LU/174/21/PL

44-48 High Street Littlehampton BN17 5ED

Replacement of 14 No. timber frame sash windows and 1 No. timber frame bay window to residential units. This application is in CIL Zone 4 (zero rated) as other development

| Project<br>Proposed | Sheet<br>1/1 |

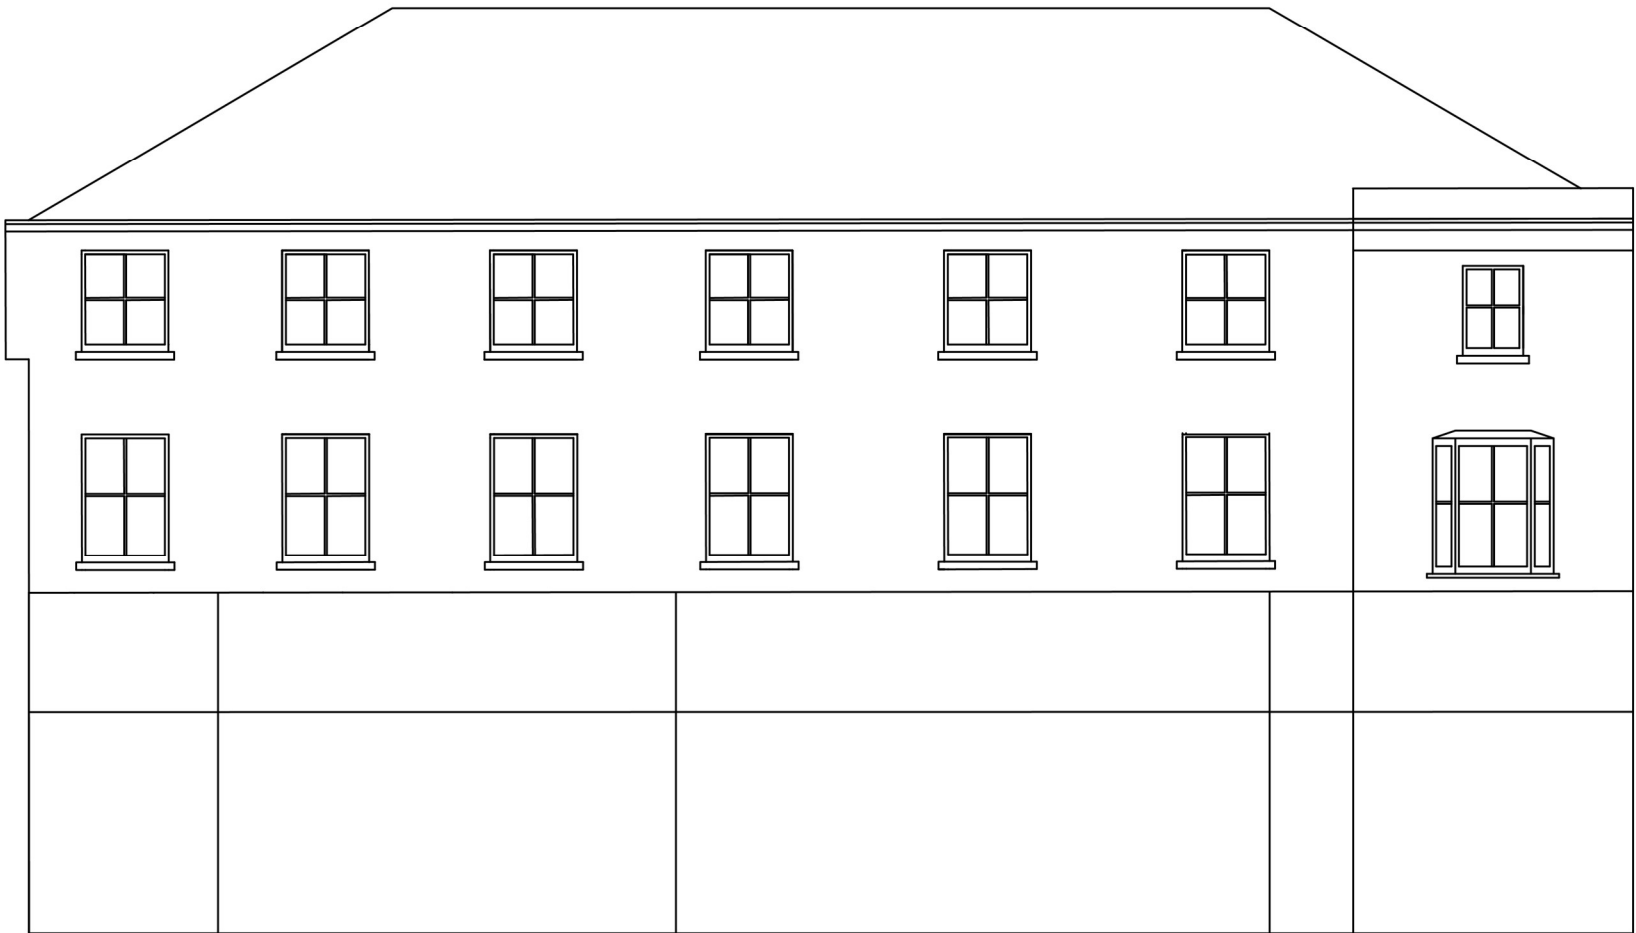
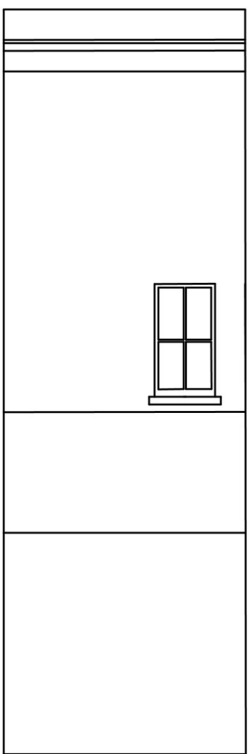
The use of traditional materials would be more appropriate in this positive building, and the use of UPVC is disappointing. If the appearance of the windows is to remain the same, and the dimensions of the frames and glazing bars similar to the existing ones, the impact could be reduced. At present, there is potential for the proposal to be harmful to the non-designated heritage asset.

The use of UPVC is considered to be problematic and therefore harmful. The application should therefore be determined in accordance with the relevant policies within the Development Plan, paragraph 197 of the NPPF, along with these comments.
